**Consultation Response from KC,
Highways Development Management**

2024/92504 134, Birkby Hall Road, Birkby, Huddersfield, HD2 2UZ

Change of use from vehicle repair and sales to vehicular repair, sales and hand car wash with associated works (within a Conservation Area)

Date Responded: 09/01/2024.

Drawing Title:  
EXISTING AND PROPOSED PLAN.

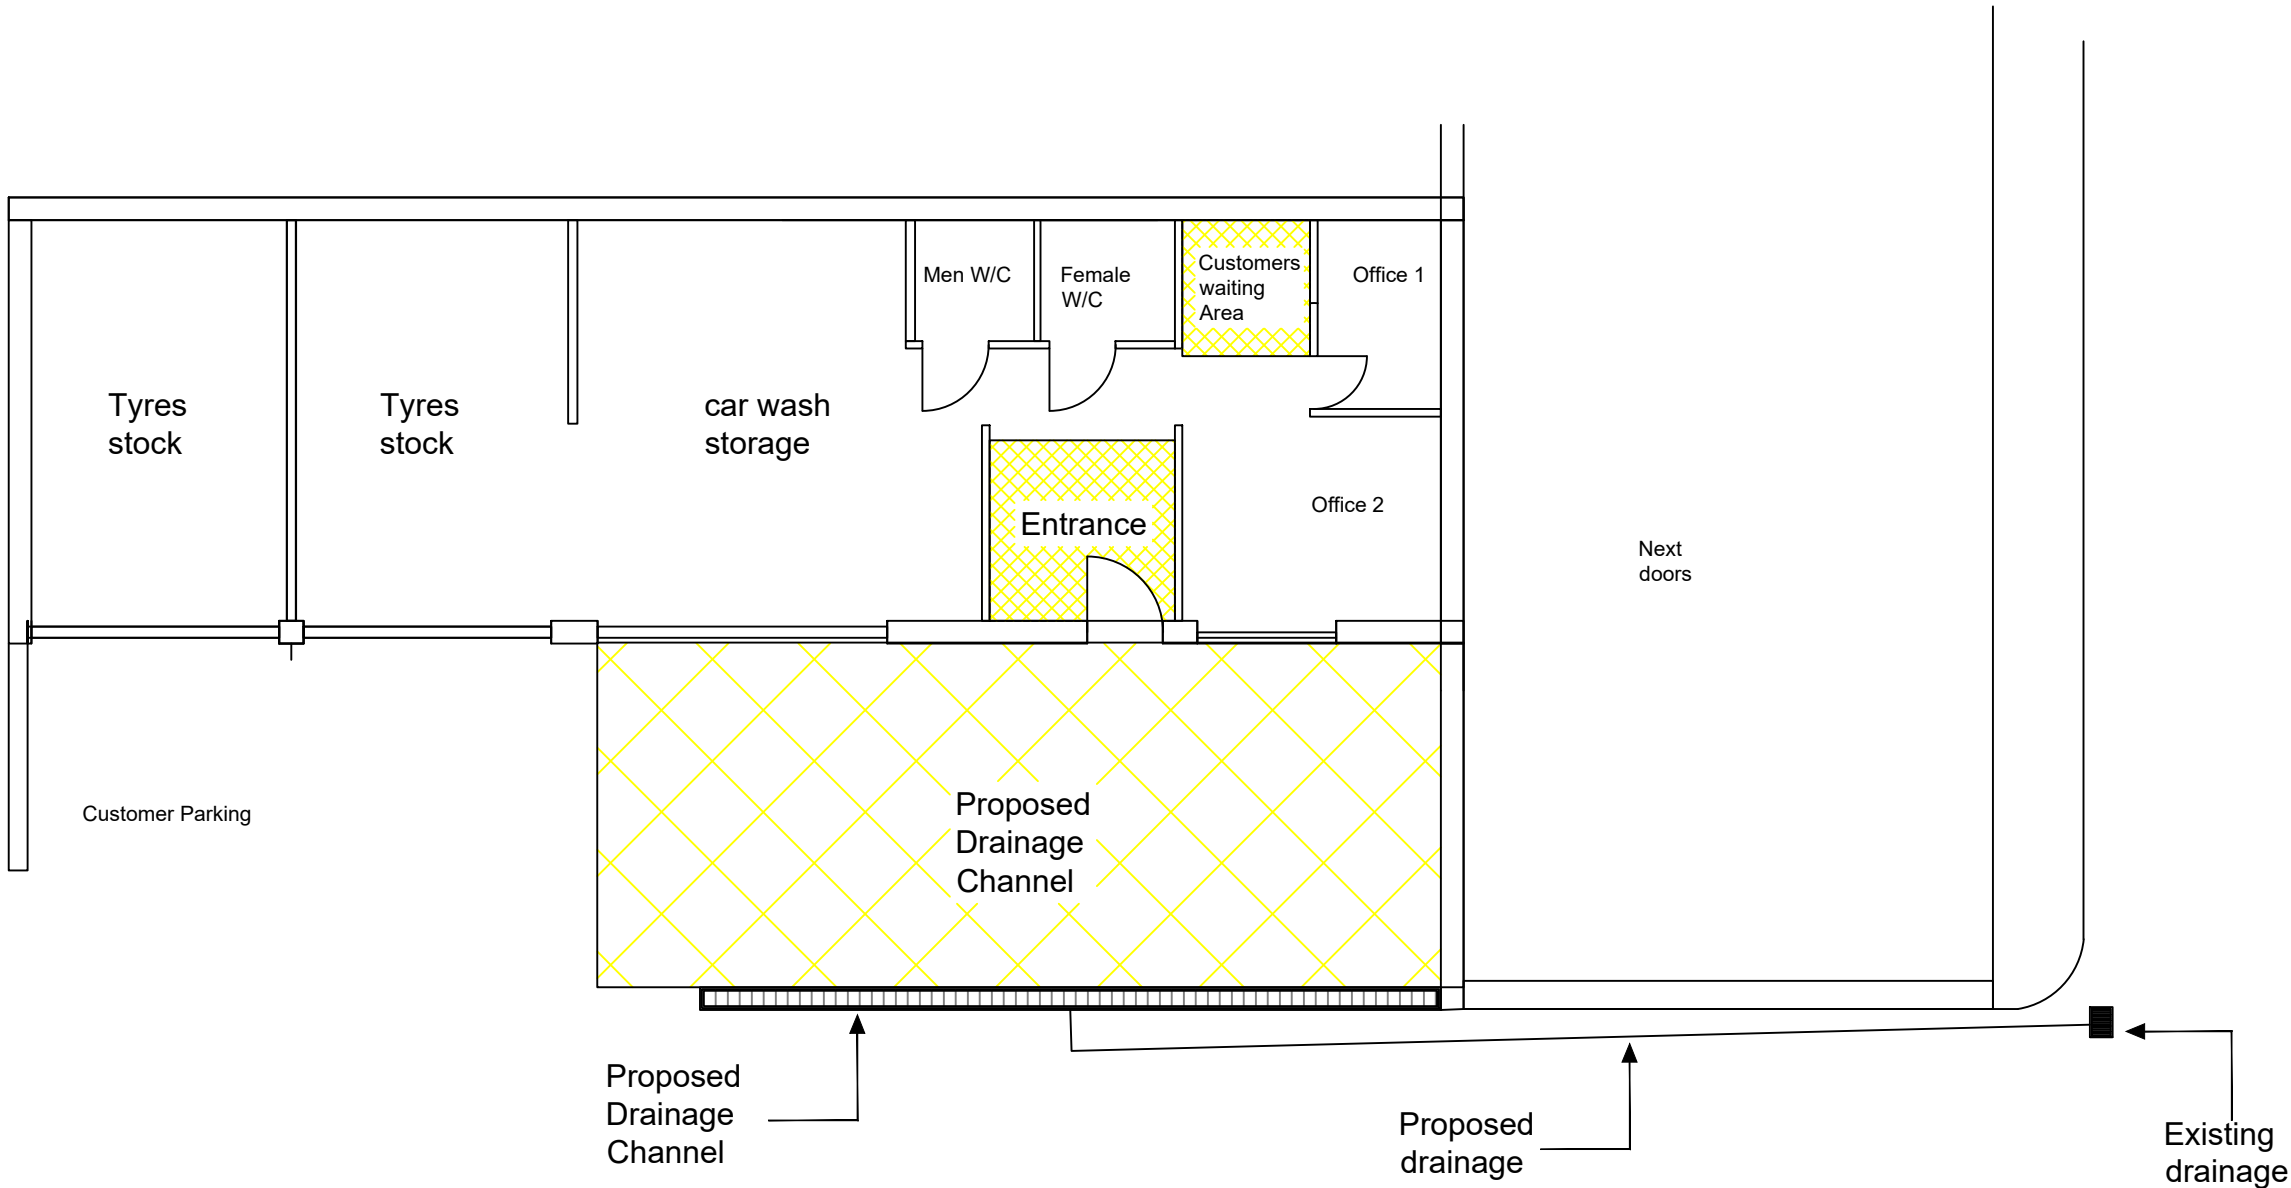
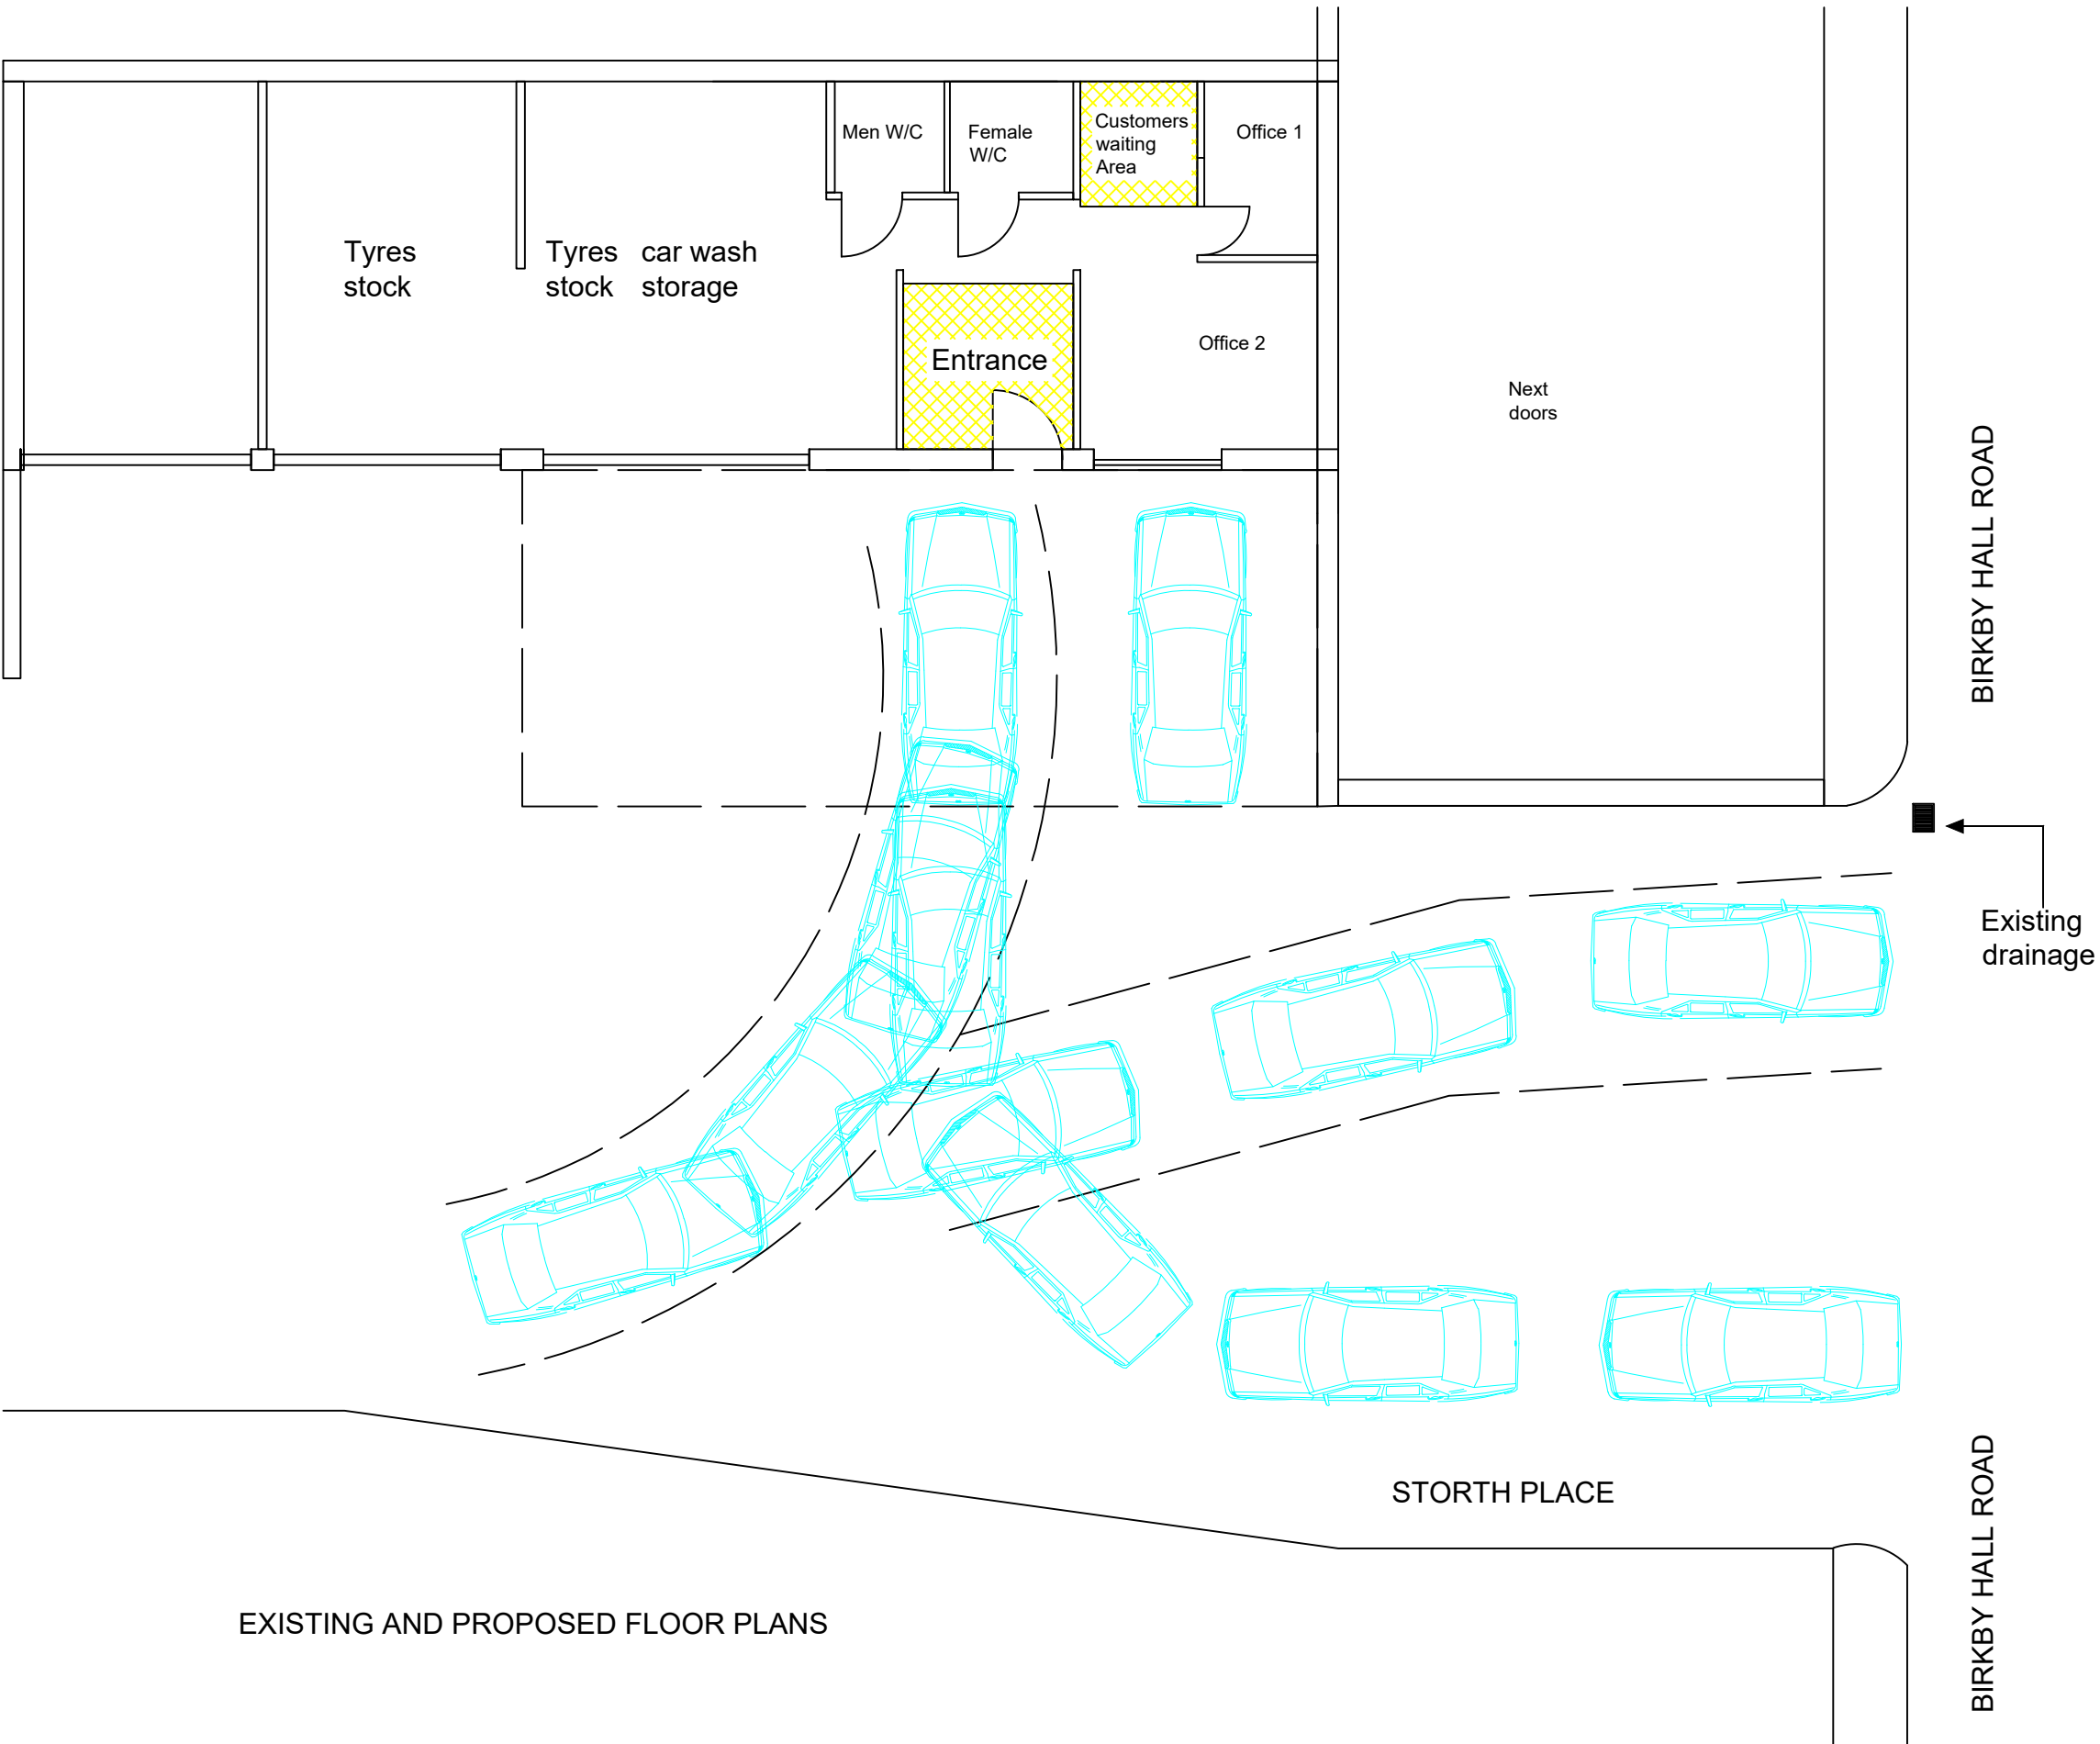
The existing site already appears to be a well-used area, and the car wash will generate additional traffic to the site which does not have the space to adequately accommodate waiting vehicles.

Vehicles queuing will do so on the adjacent Storth Place and potentially onto Birkby Hall Road obstructing the flow of traffic and creating a road safety issue.

Storth Place is the access to and adjacent to the development site. This road is unmade and does not have a separate footway. The carriageway is, therefore, used as a shared surface by vehicles, cyclists and pedestrians and should not be used for parking or queueing.

As a result, I would consider that the addition of a car wash is an overdevelopment of the site leading to parking and loading/unloading taking place on Storth Place and potential queuing on Birkby Hall Road to the detriment of road safety on the adjacent PROW/Access Road.
